Our ref: P23-2074
LPA Ref: 22/03063/F

**Planning Application for Erection of 126 dwellings with access from Camp Road, provision of public open space and associated infrastructure
Land East of Larsen Road Heyford Park**

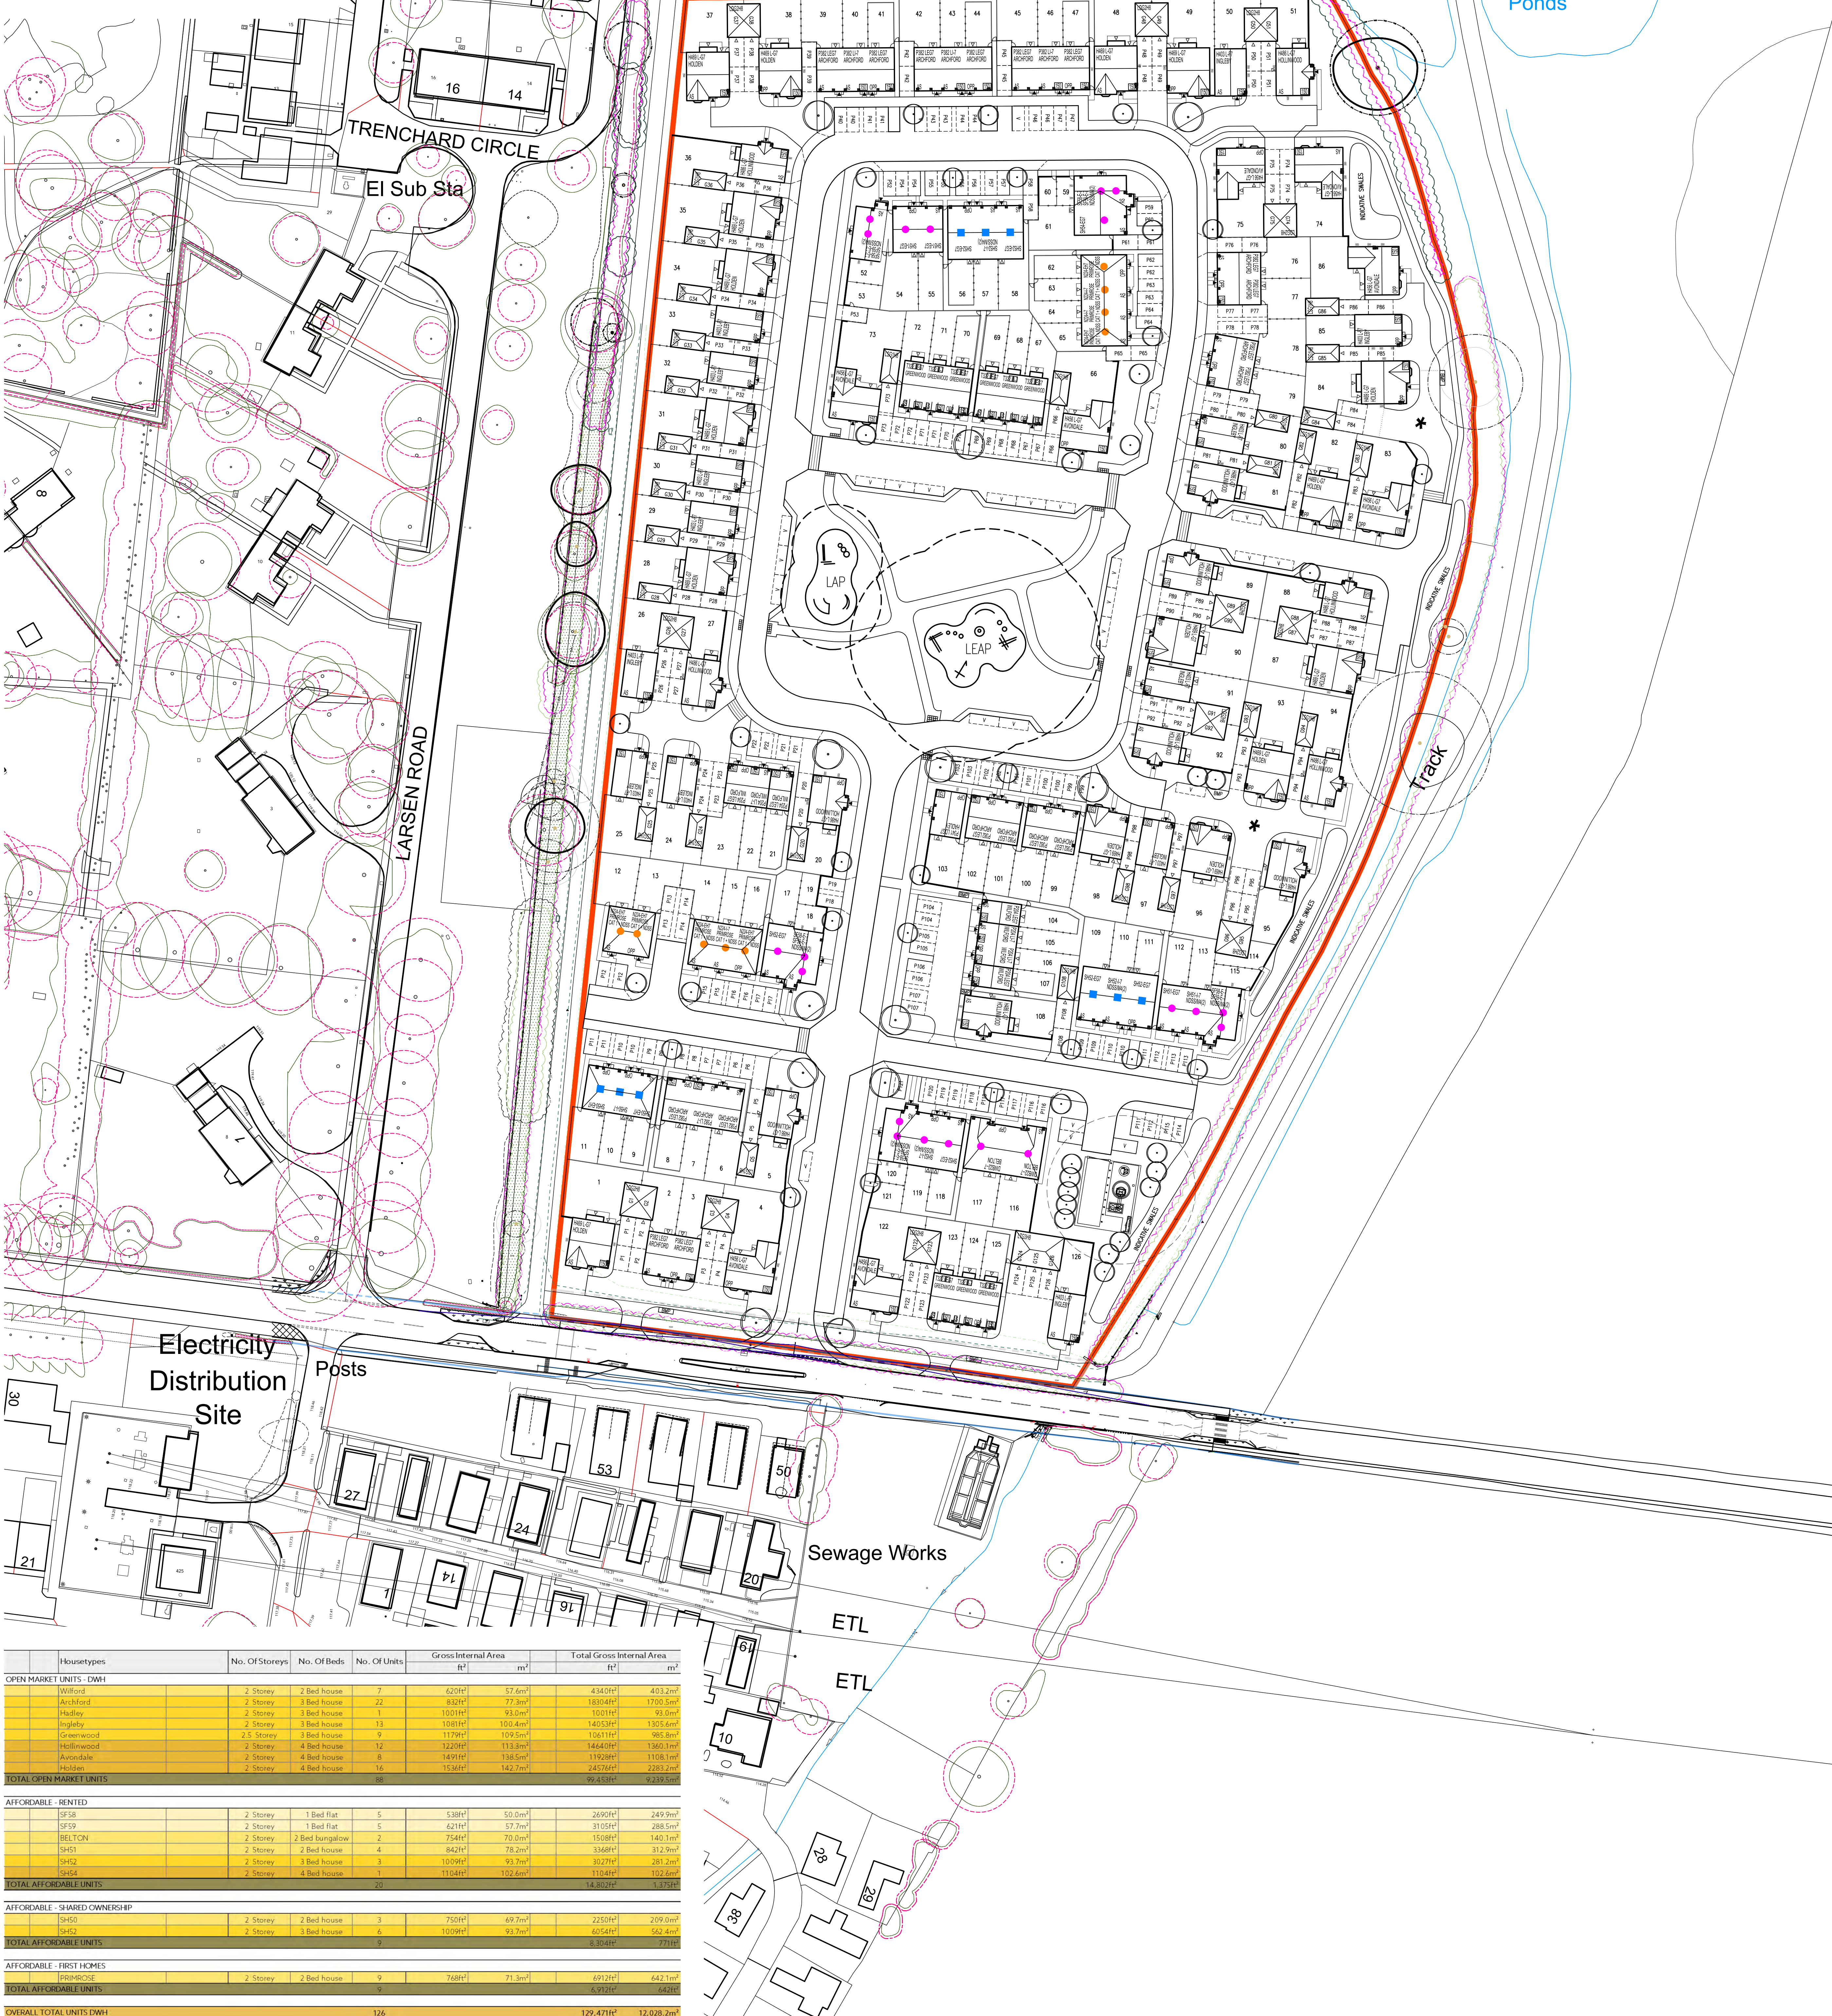
It is noted that the revised Planning Layout Plan ref. 0778-102B now includes a pedestrian link to adjoining PV5 land in the north western corner of the site, to the front of plot 37. The principle of creating this link is welcomed given the policy context outlined above. It also reflects that which was secured through condition 4 of the Pye Homes planning permission (LPA ref 21/03523/OUT).

In order to meet the objectives of Policy PV5 it is important that a link is provided all the way to Larsen Drive. Given that this involves land beyond the red line boundary it will (as before) be necessary to impose a Grampian condition. The previous condition was however poorly drafted. We consider that the following wording would be more appropriate:-

“No development hereby permitted shall be begun until details of a scheme of access for pedestrians and cyclists is submitted to and approved in writing by the Local Planning Authority to secure a link from Larsen Road to connect with the proposed pedestrian link shown to the front of plot 37 on drawing ref. 0778-102B.

No dwelling on the plots 31 to 85 inclusive shall be occupied until the link from Larsen Road has been completed in accordance with the approved details.

If the link is not provided, we consider that the application should be refused. The condition is necessary to make the proposals acceptable in policy terms.
